**DE-2012/84**

**STATE SIGNIFICANT DEVELOPMENT – RESOURCE RECOVERY FACILITY – KEMBLA GRANGE (SSD 5300) –  
RESPONSE TO SUBMISSIONS**

## **ATTACHMENT A - Comments on the Response to Submissions Report**

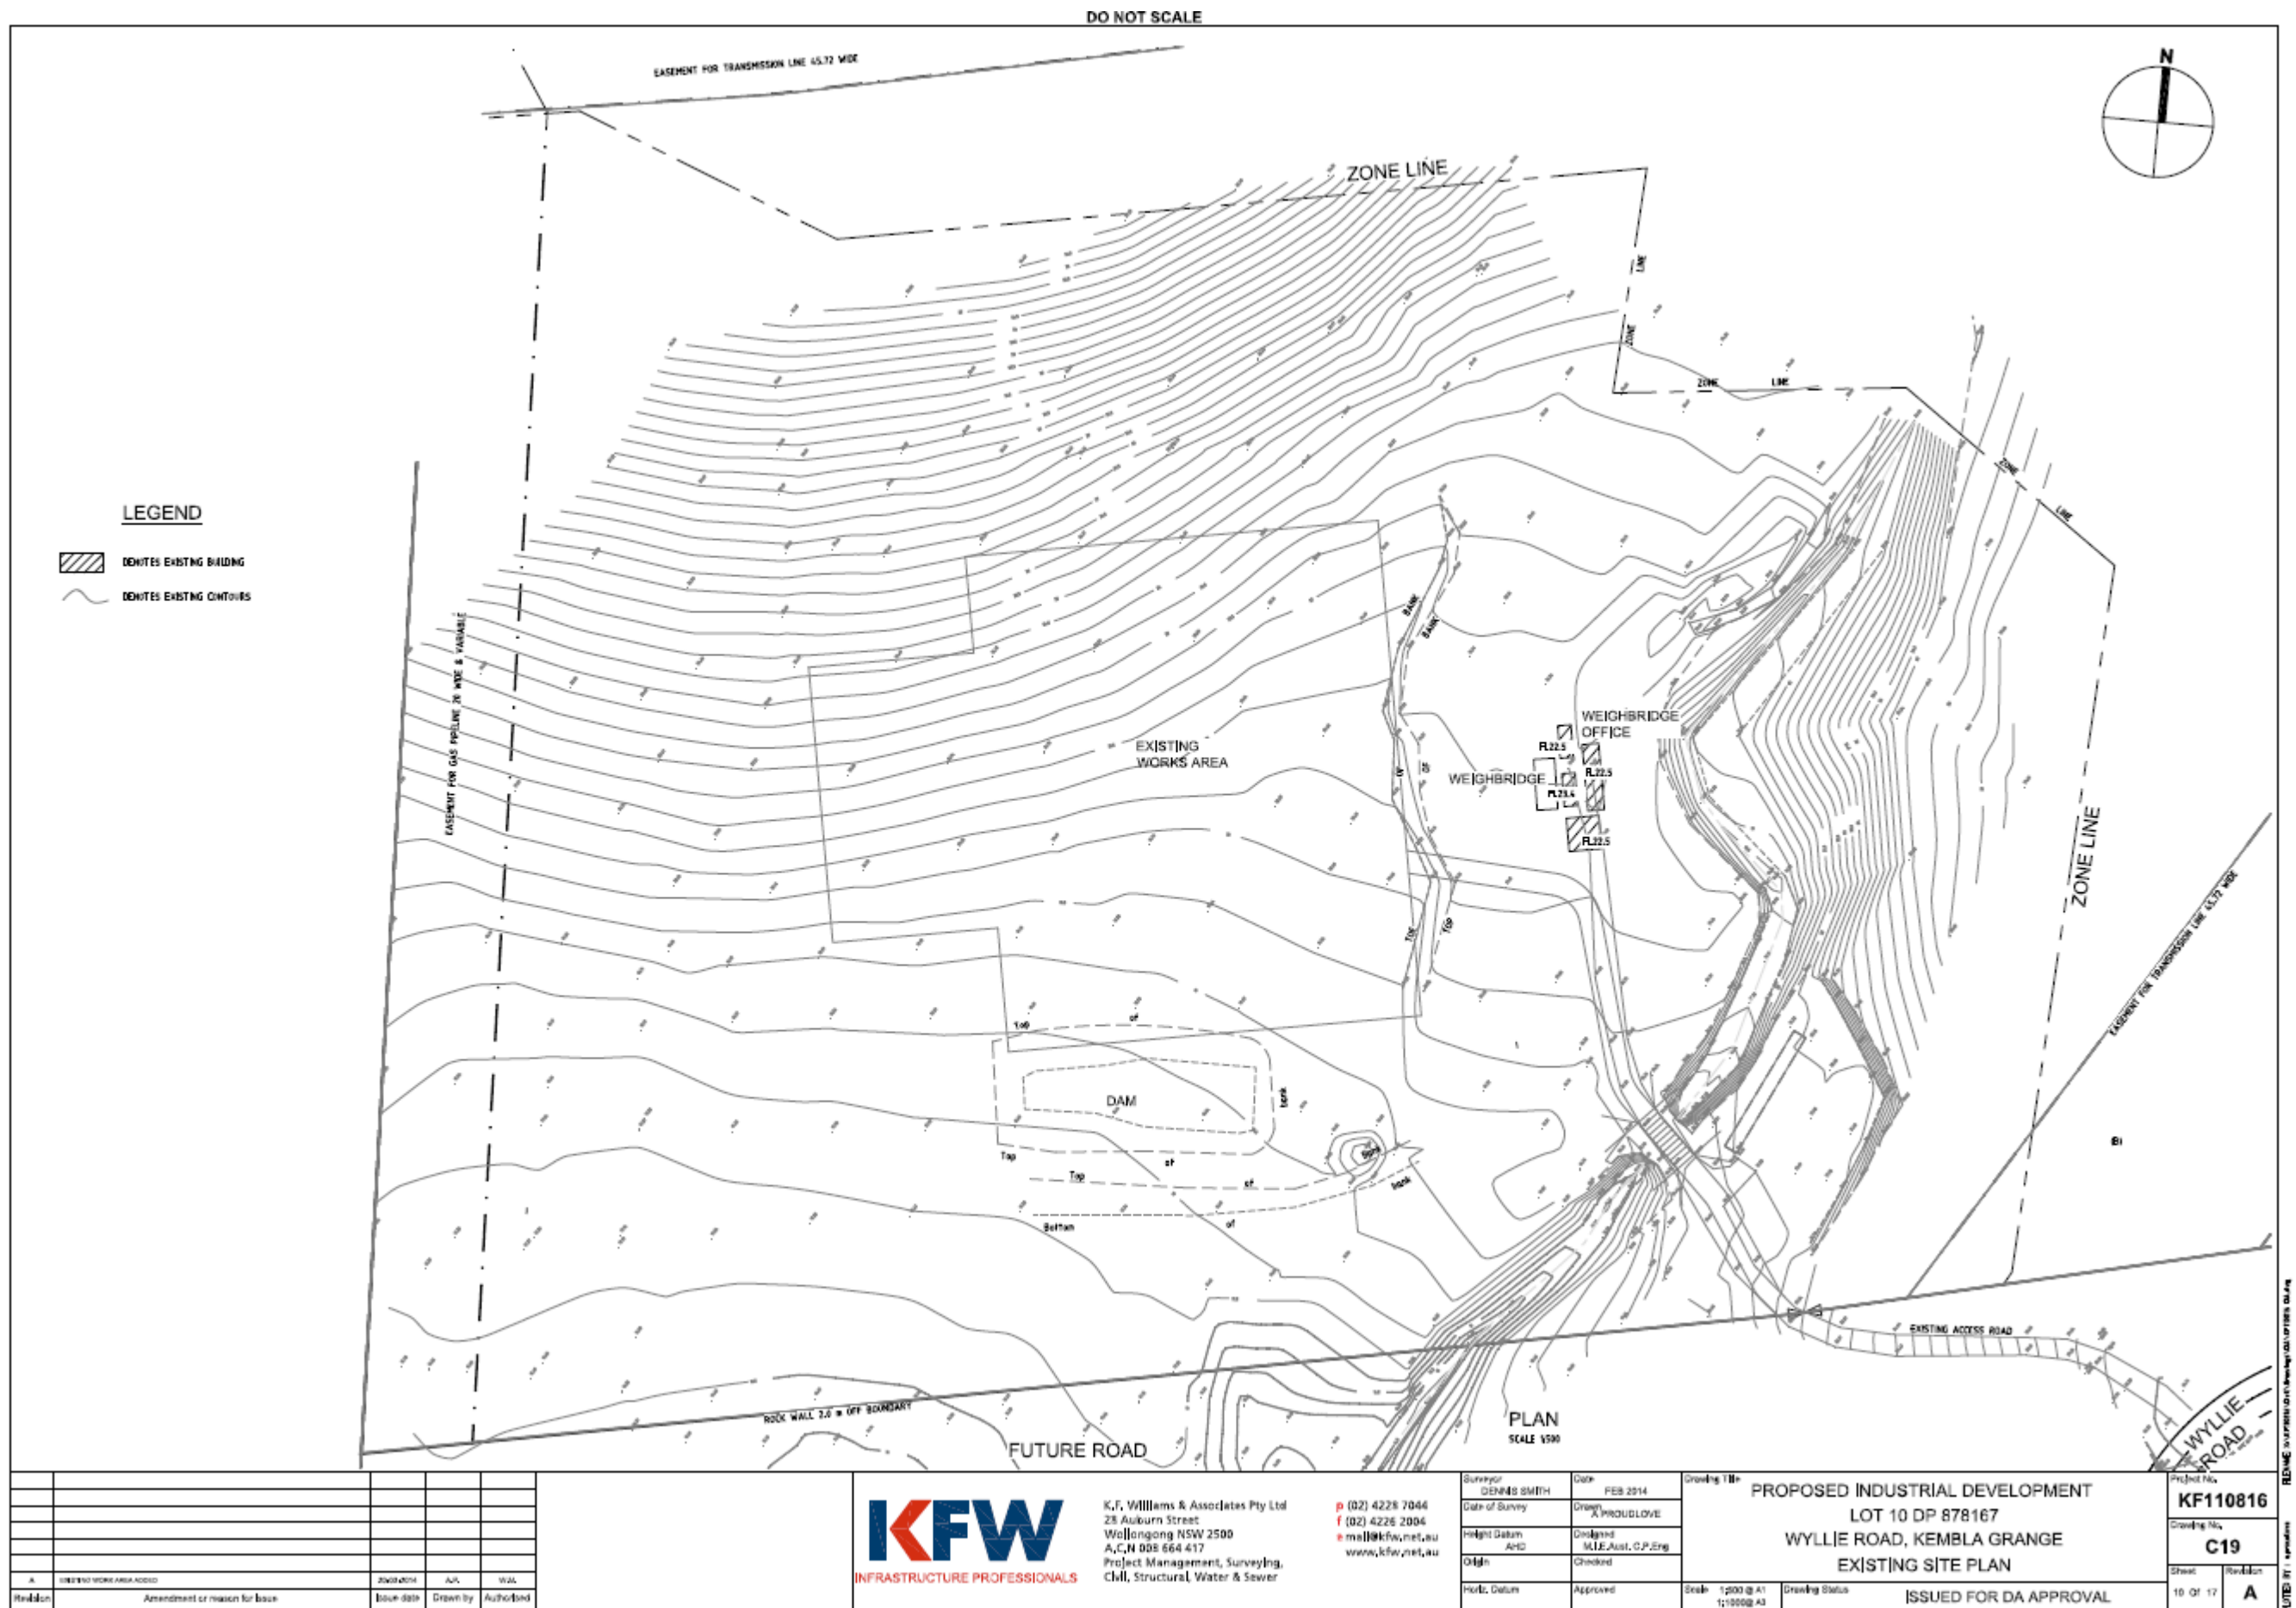
The approved plans for Modification D show 2 x 20,000L rainwater tanks south of the shed and 1 x 20,000L tank west of the equipment area. The proposed plans (site plan) in the State Significant Development no longer show the 20,000L rainwater tanks, rather 2 x 100,000L tanks west of the shed. The proposed rainwater tank east of the equipment area is 10,000L.

The discussion in Table 3 of RTS with regard to the number, size and location of rainwater tanks does not reflect the above.
